Arborist Report

April 5th, 2023

Aspen Homes/Tubbs/Gudipaty
3632 90th Ave SE
Mercer Island, Wa

A. SITE PLAN

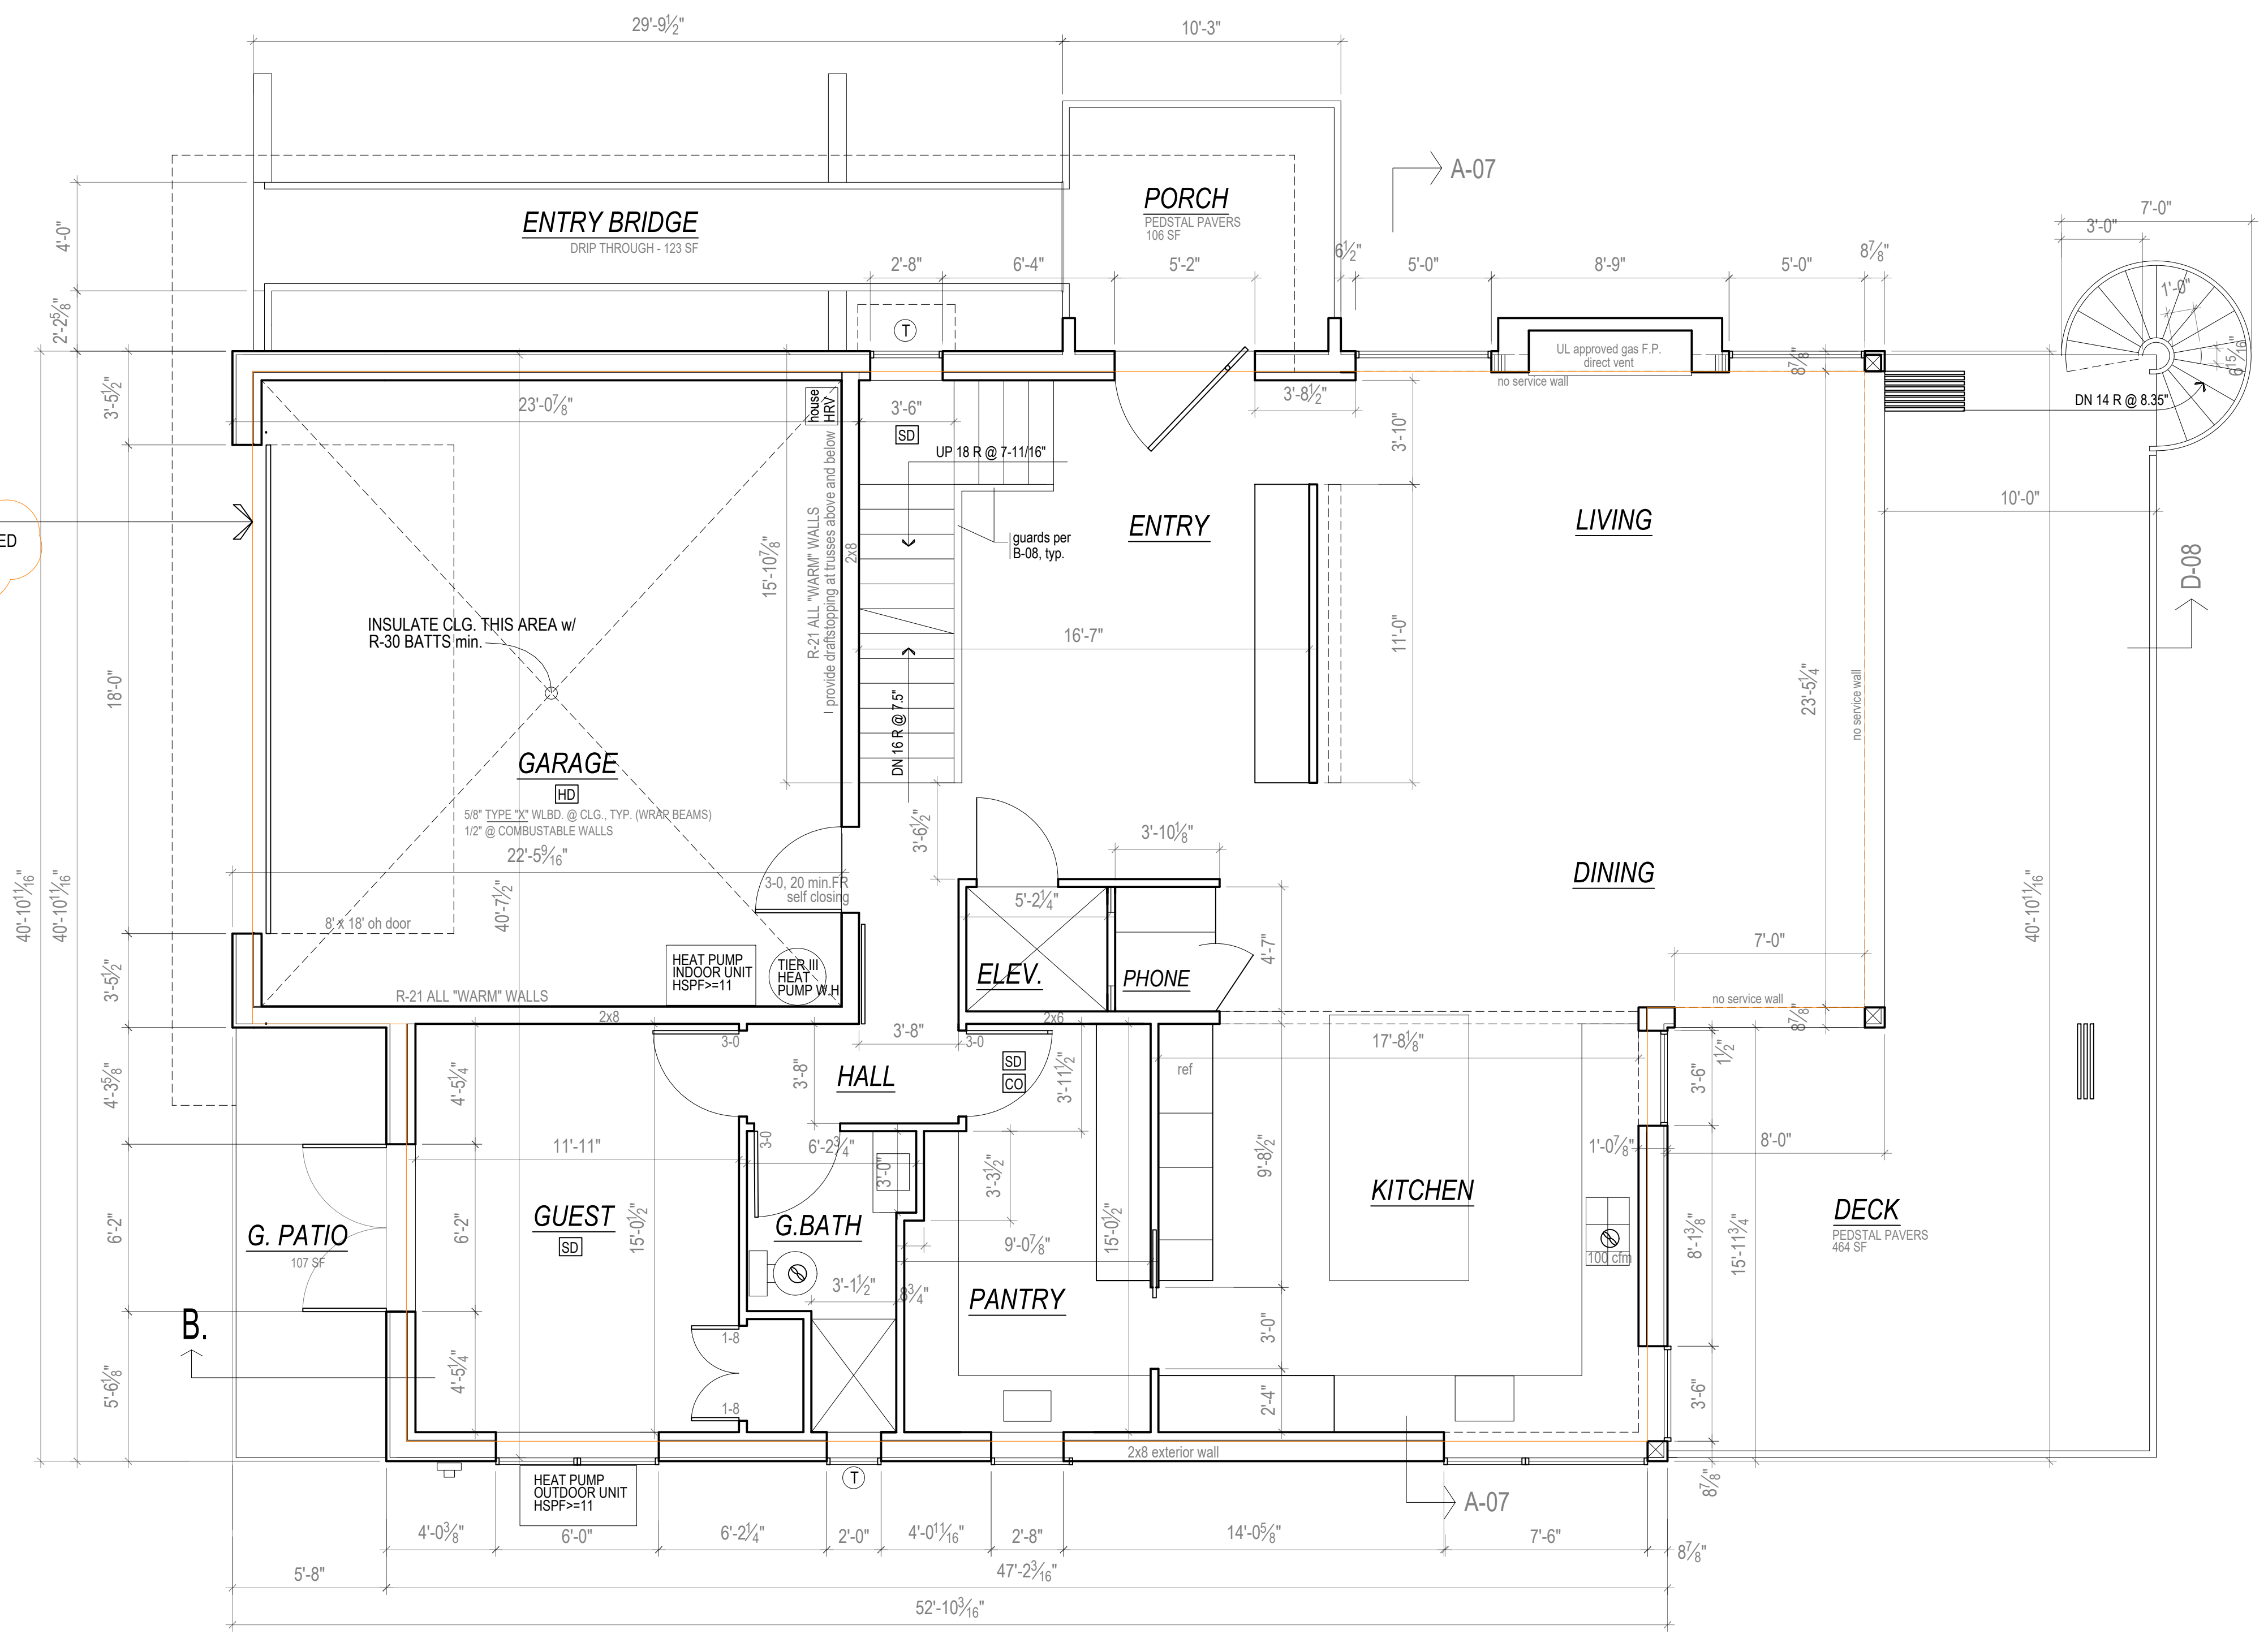
2. (From intake screening for arborist) Tree 1660 is exceptional in size. The arborist report does not indicate this or cite the correct tree code MICC19.10. The report must be updated with the correct standard for regulated and exceptional trees. Driplines or tree protection zones must be provided for all regulated trees. See checklist for all requirements.

Since discovering that this is an Exceptional Tree, that client has moved the proposed new building north to avoid the Tree Protection Zone. The Tree Protection Zone (congruent with the Critical Root Zone) is a circle with a 13' radius that has its centerpoint in the middle of the tree. Tree Protection Fencing should be installed at the tree's drip line prior to construction activities commencing and remain in place for the duration of the project. The TPZ should have 4" of mulch added to assist with water retention during the building process and to help build ideal, lasting soil conditions for the tree.

Revised Footprint Avoids Tree
